Our Ref: LU/54/17/HH
Your Ref:

Town & Country Planning Act 1990 (as amended)
Town & country Planning (Development Management Procedure) (England) Order 2015
Application for Planning Permission for Works or Extension to a Dwelling

Development Proposed extension
Location 5 Camelia Close Littlehampton

Itemref	Quantity	Title/Name, designation, material, dimension etc	Article No./Reference
Designed by	Checked by	Approved by - date	Date
5 Camilia Close		Proposed Extension	1:50
01		Edition	Sheet

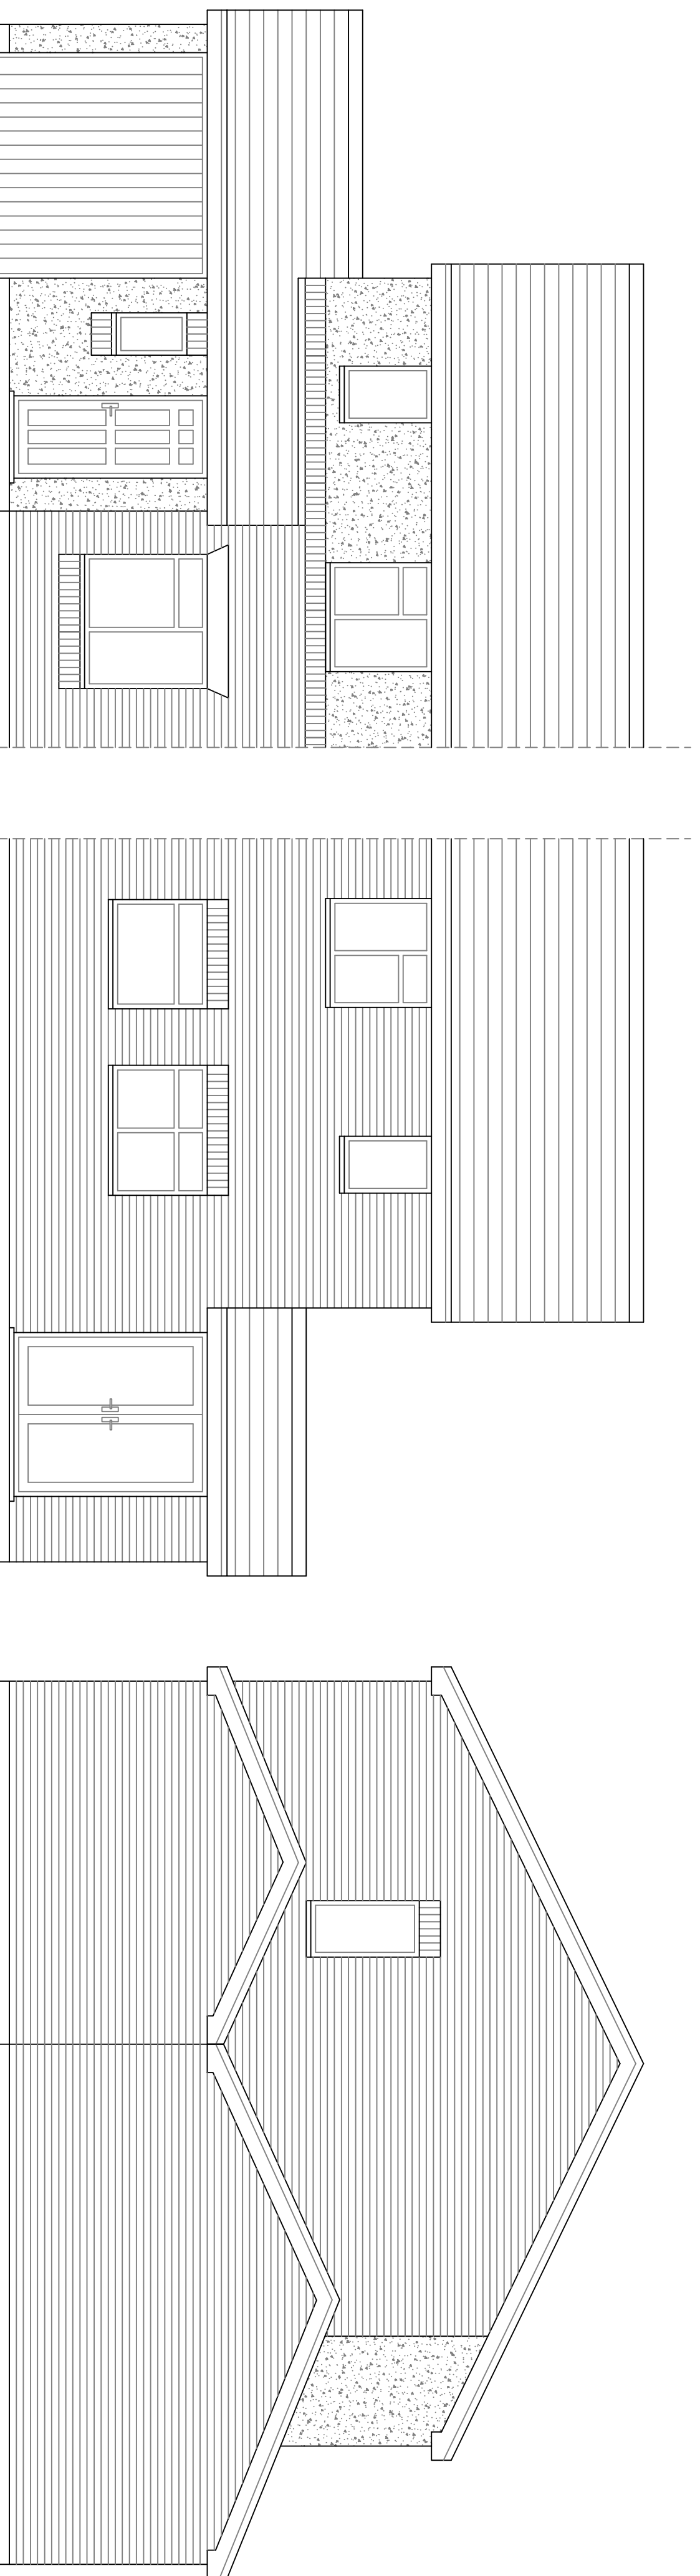
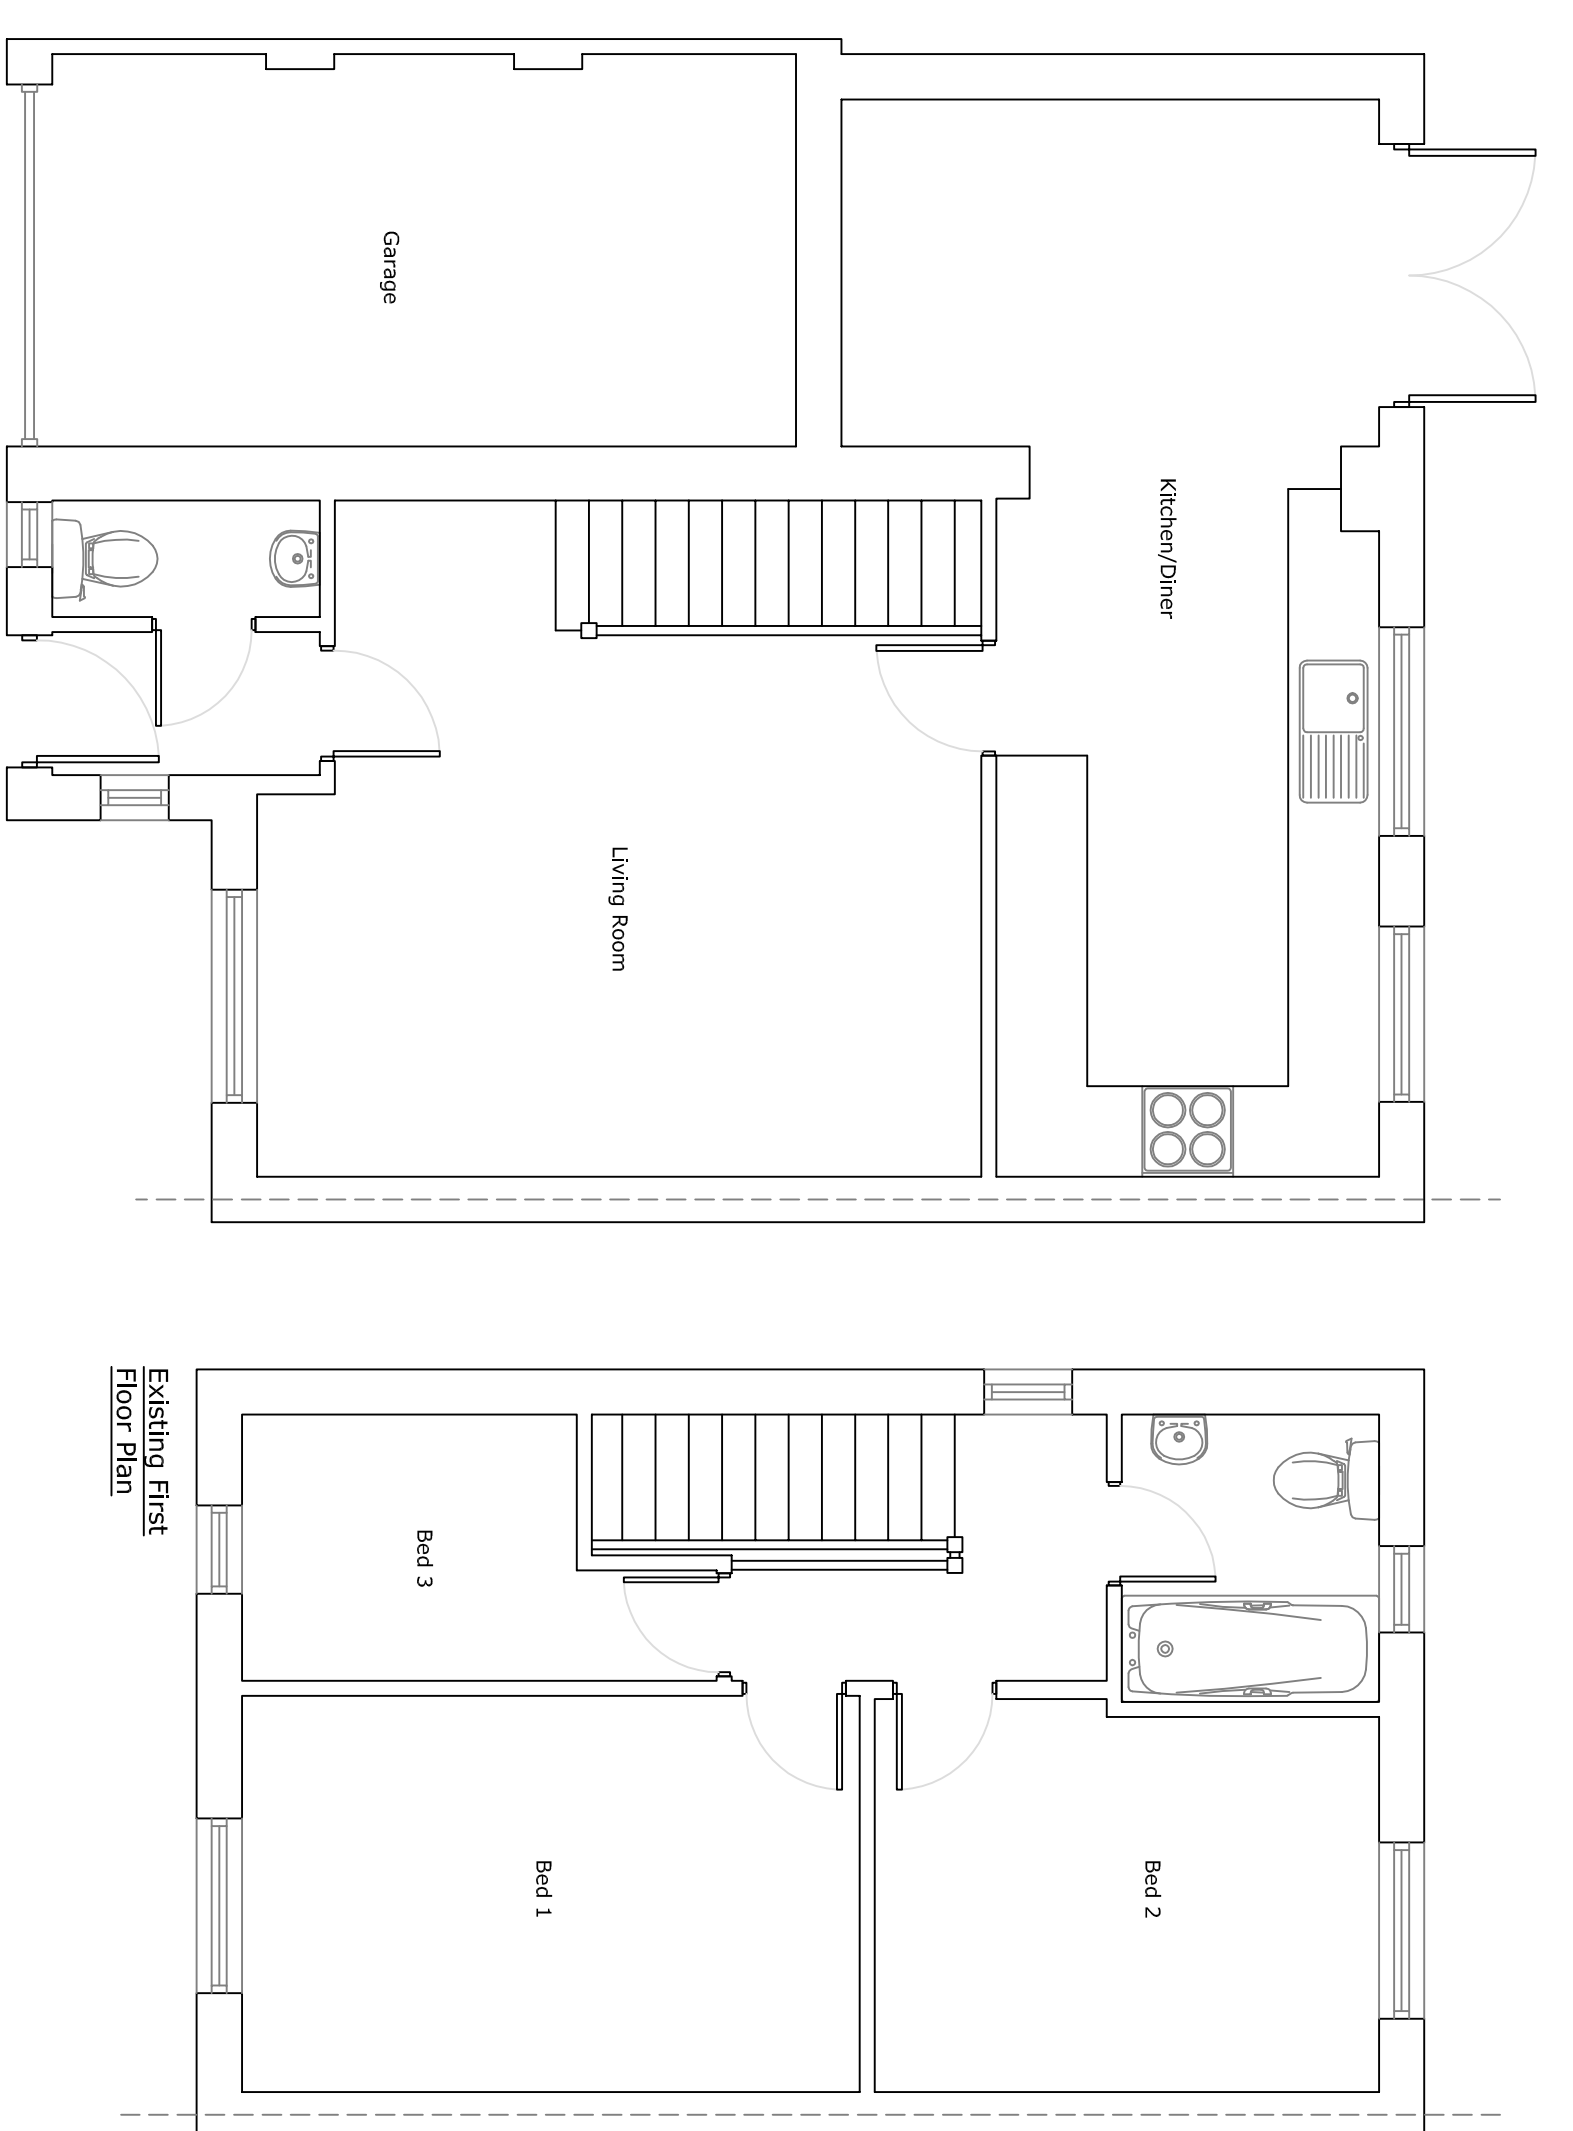
Plans Inconsistent

The window inconsistent between the proposed first floor plan and side elevation.
